Your ref:	70 Charlbert Court Windows Re...	Please reply to:	Fraser Fikrie
Our ref:	24/00629/FULL	Tel No:	0753424 7967
		Fee Queries:	0207 641 6500;
		Email:	planningreception@westminster.gov.uk;
Mr Ming Wong 70 Charlbert Court Charlbert Street St John's Wood London NW8 7DB United Kingdom		Incomplete Applications Town Planning & Building Control City of Westminster PO Box 732 Redhill, RH1 9FL	
		4 March 2024

Address: 70 Charlbert Court, Charlbert Street, London, NW8 7DB,

Proposal: Replacement of windows and a back door with aluminium double glazed casement windows and a Visofold 1000 single door.

TITLE: PROPOSED ELEVATION REAR	CHECKED: AM
SCALE AT A3: 1/75	DATE: 12.03.24
PROJECT NO: 1206	DRAWING NO: A3/04B
	REVISION: B

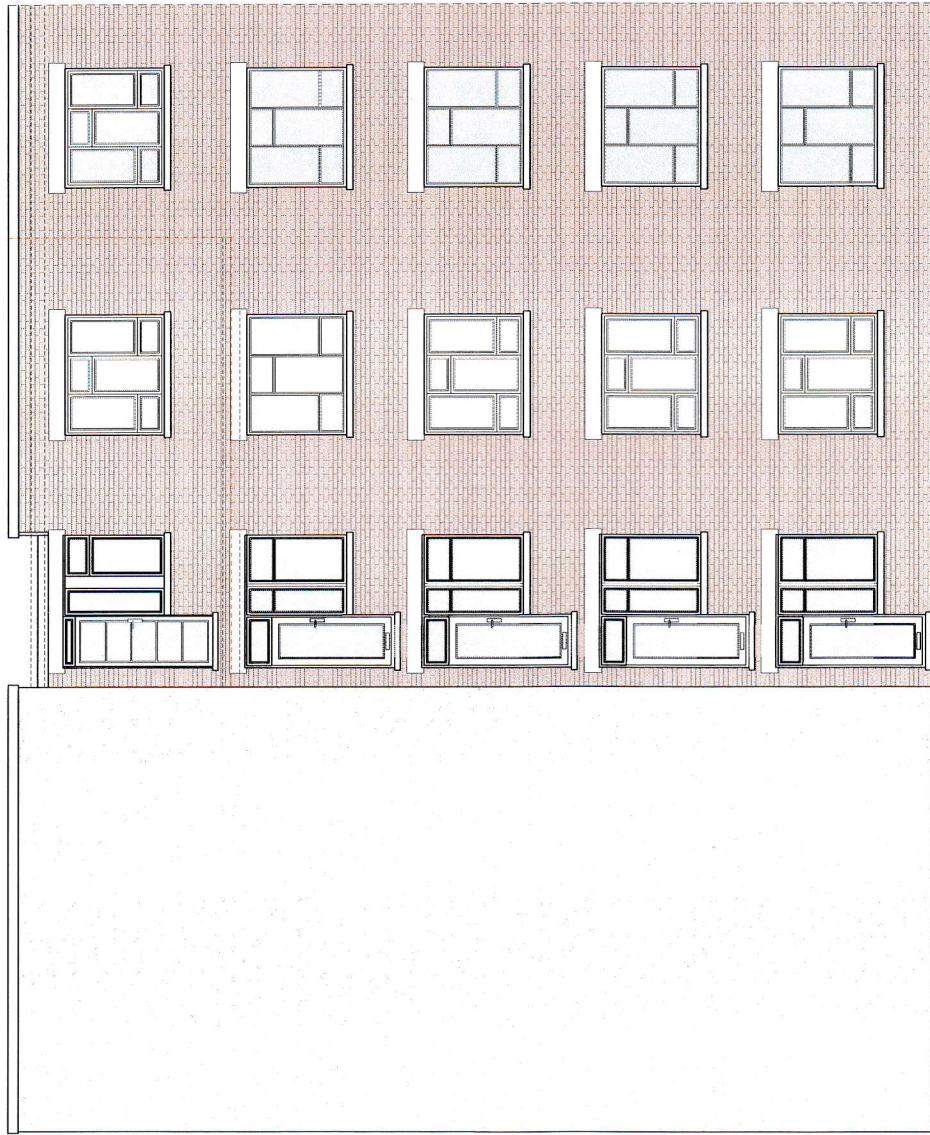
- 1 Please provide:
- Existing and proposed elevations (architectural elevations) in context to the whole building annotating the windows affected.
 - Existing and proposed detailed drawings (section through) of the windows.
